DECISION DELEGATED TO HEAD OF PLANNING

Application No: H22-0853-23 **Applicant:** George Hay & Sons Ltd

Proposal: Conversion of barn to single dwelling to include demolition of lean-to

Location: Agricultural Barn To The North Of Weston Barn House Marsh Road
Weston

Drawing
Proposed Plan & Elevations

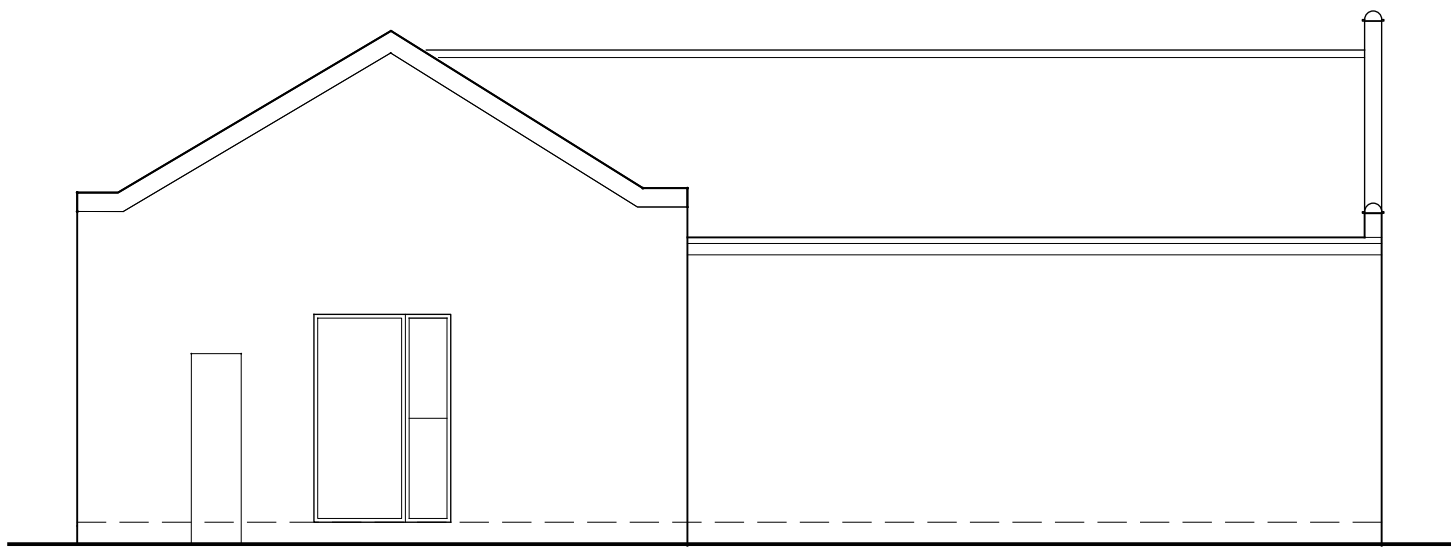
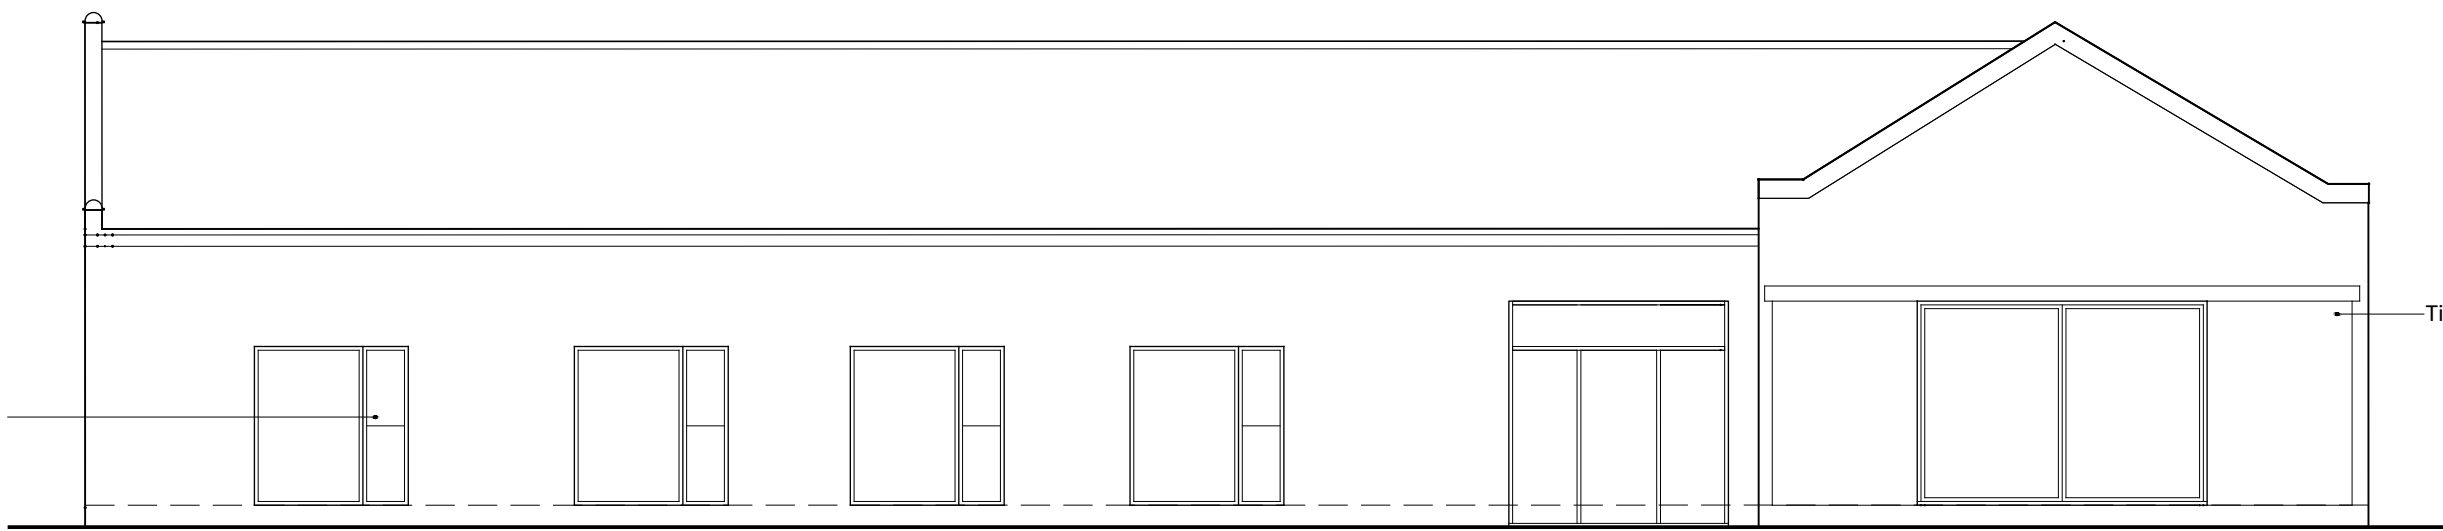
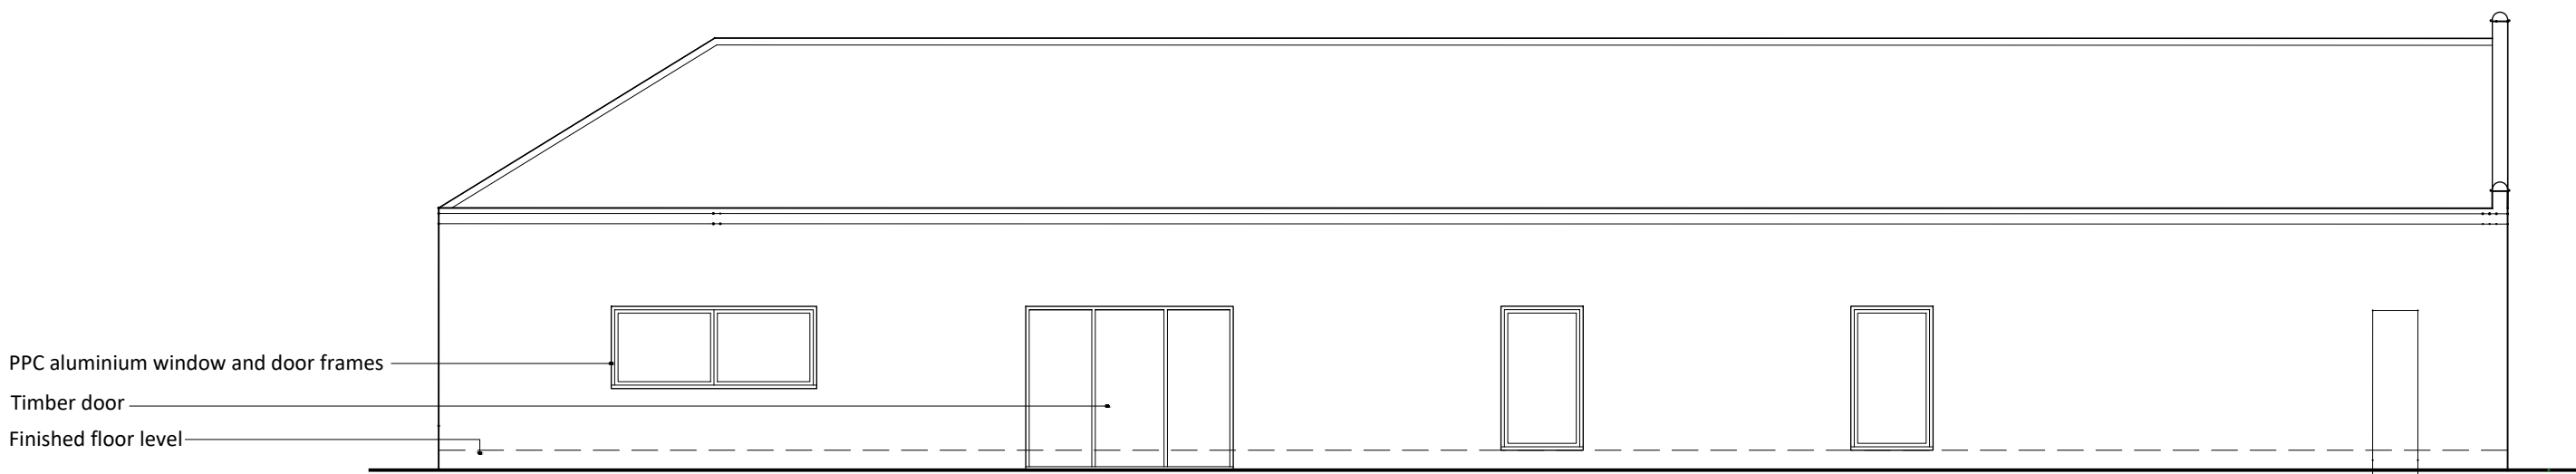
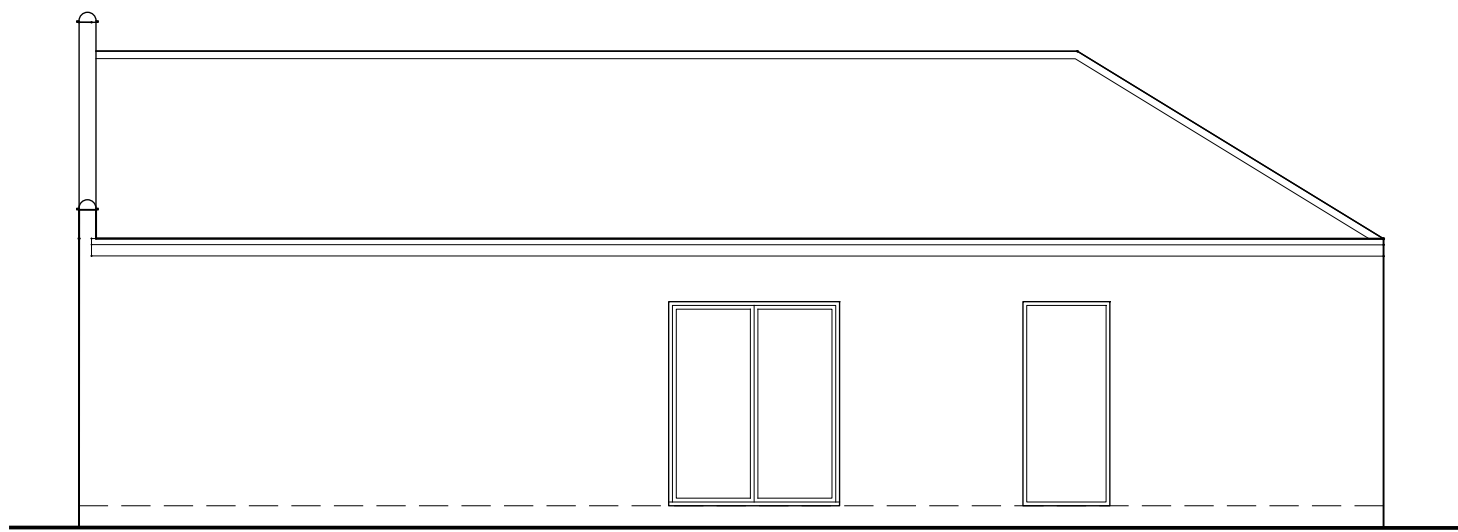
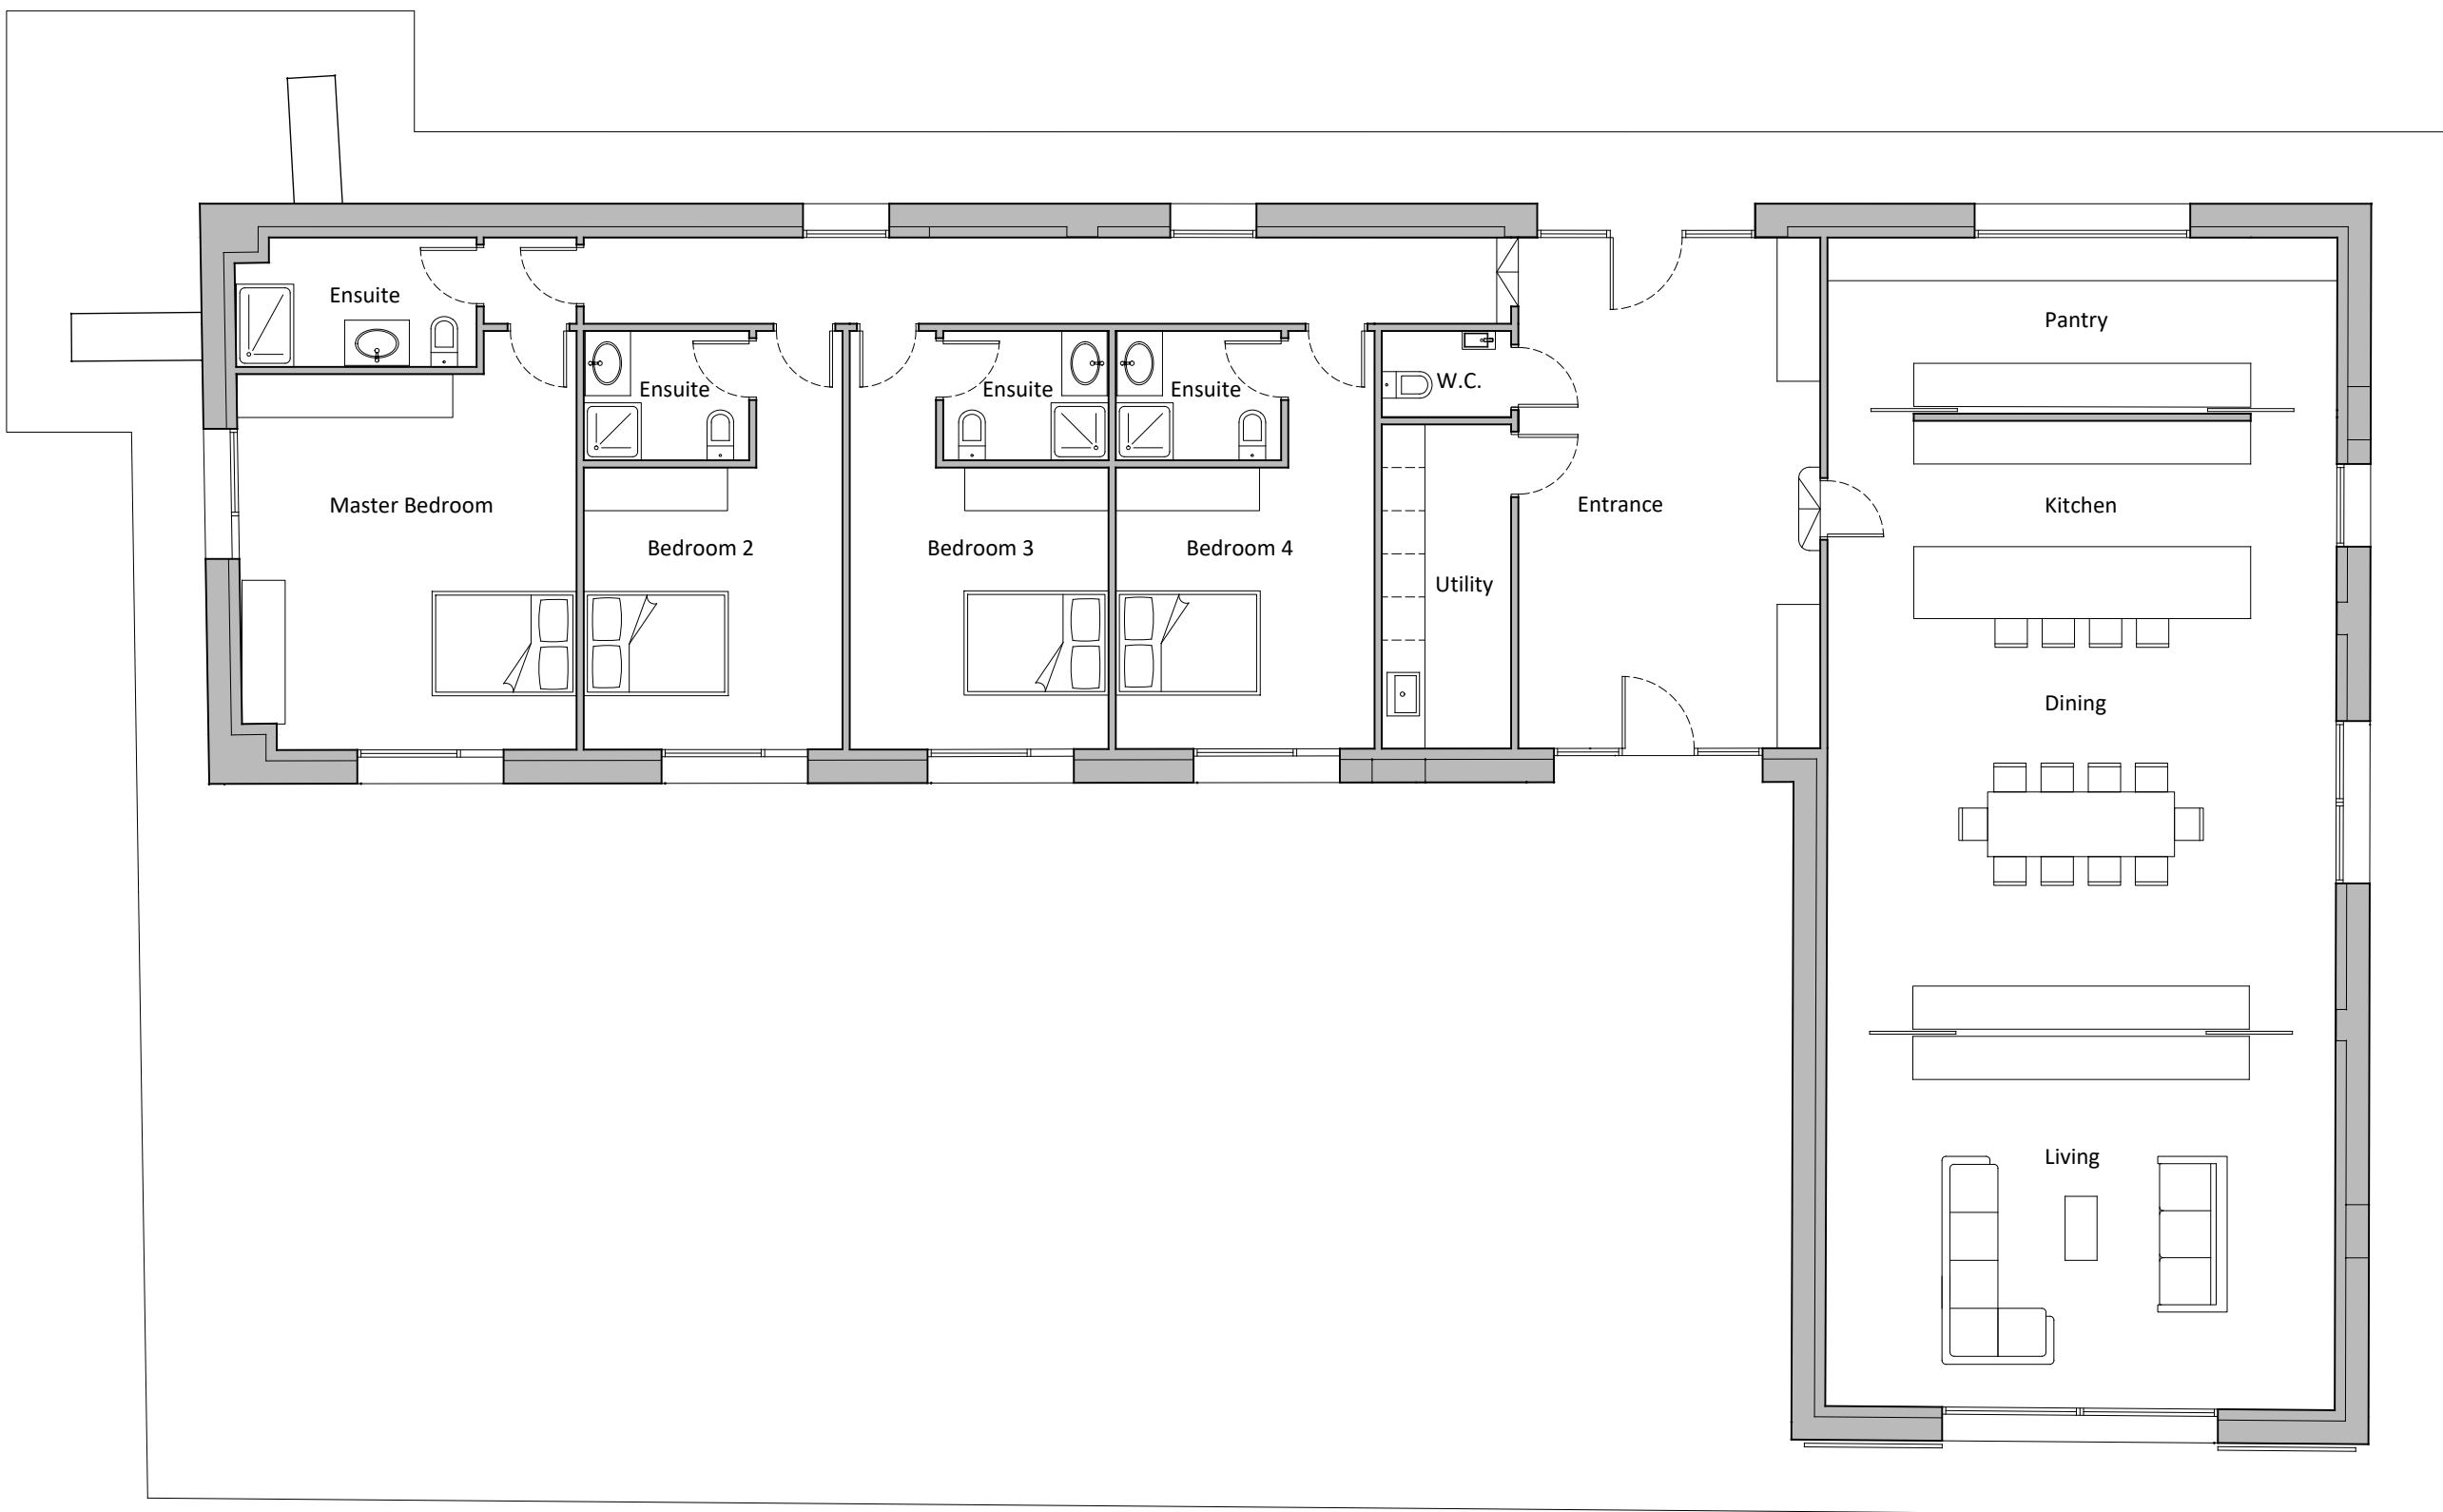
The proposal would retain the architectural form of the barn. This building is well-established and has informed the character of the open countryside for many years, the lean to would be demolished and the building is not compatible with modern agriculture; this is precisely the type of development that class Q sought to approve.

The openings are a mix of aluminum and timber and the amount proposed is required to provide future residents with sufficient amenity. The architectural features of the barn would remain

unchanged, and the plans shows no changes to the facing brick. The building is highly visible and any changes would have an effect upon the character of the open countryside, it is considered necessary to remove the ability for the erection of fences and boundary treatments. A poorly executed scheme would have a detrimental impact upon the character and landscape of the area and so details would need to be agreed prior to their erection. It is therefore considered that the design of the proposal is acceptable.

As touched upon in the last section the openings would offer a high level of amenity for future residents. All rooms that require it are served with adequate natural light. The proposal in these terms is considered acceptable.
